RE: MP06_0310-Mod-4 Emirates One&Only MOD 4 – Temporary Changes to Helicopter Transport

Thanks for allowing the Australian Climbing Association NSW to submit feedback and recommendations about the proposed *MP06_0310-Mod-4 Emirates One&Only MOD 4 - Temporary Changes to Helicopter Transport*

Figure 3. Preferred flight paths.

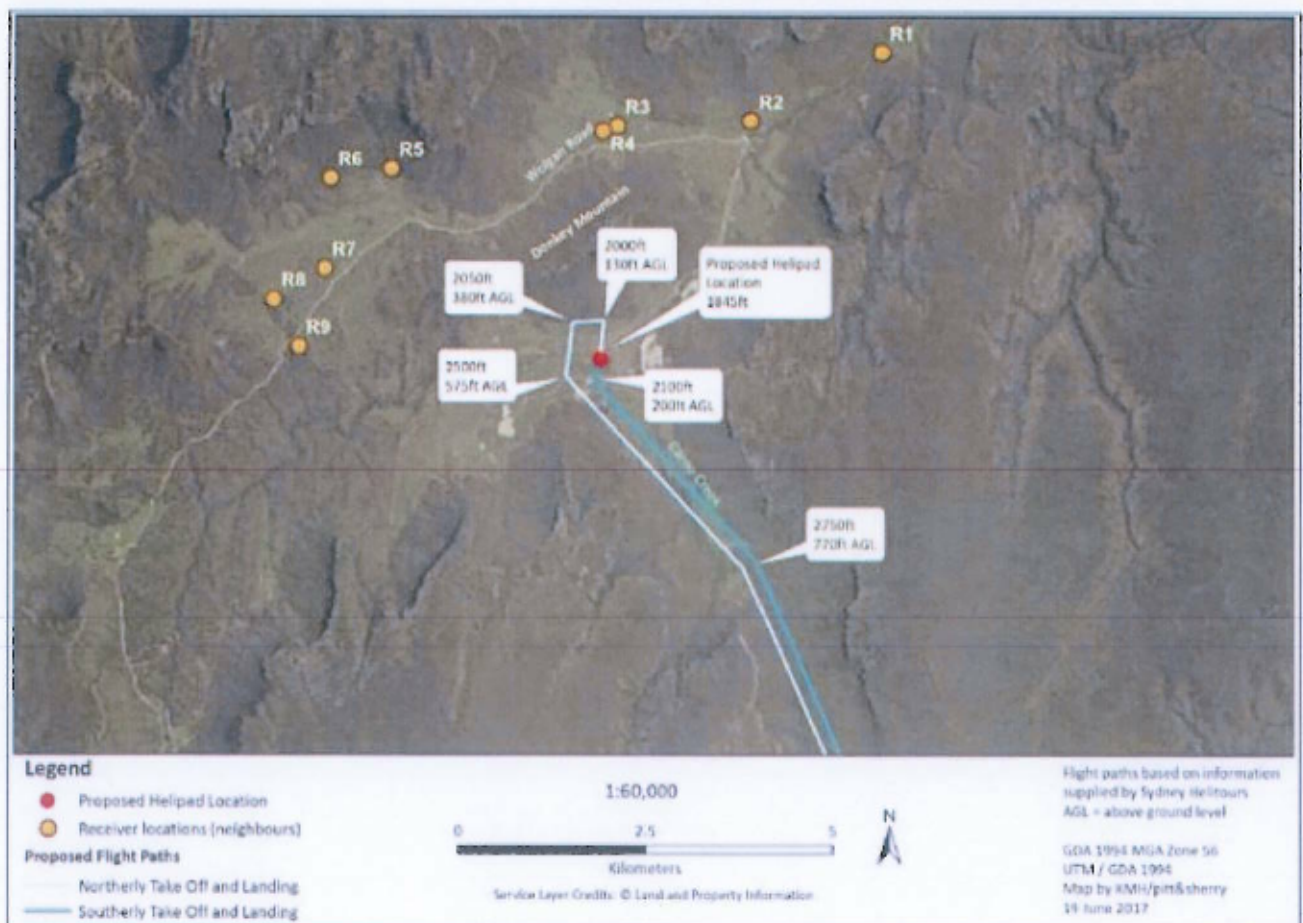
Flights paths used by helicopters from Emirates One&Only Wolgan Valley directly cross established and well used rock climbing areas located within National Park managed land.

The Australian Rock Climbing Association NSW (ACANSW) prefers the proposed modified flight path (across Gardens of Stone State Conservation Area and Wolgan River) in preference to the current approved flight path down Carne Creek. This is because Carne Creek has greater use by rock climbing user groups and past use of Carne Creek as a helicopter flightpath was seen as highly detrimental to rock climbing safety. Carne Creek area contains hundreds of recognized climbing routes, some that are considered world class and visited by international climbers.

The proposed modified flight path still crosses rock climbing areas on Sunnyside Ridge Plateau in Gardens of Stone State Conservation Area including [Sahara Point](#) and [Firecat Walls](#) that contain a total of 82 recognized climbing routes.

Altitude charts as part of this modified proposal document show the helicopter operating within 200m vertical metres of escarpments that are used as rock climbing areas which would severely affect safety communication.
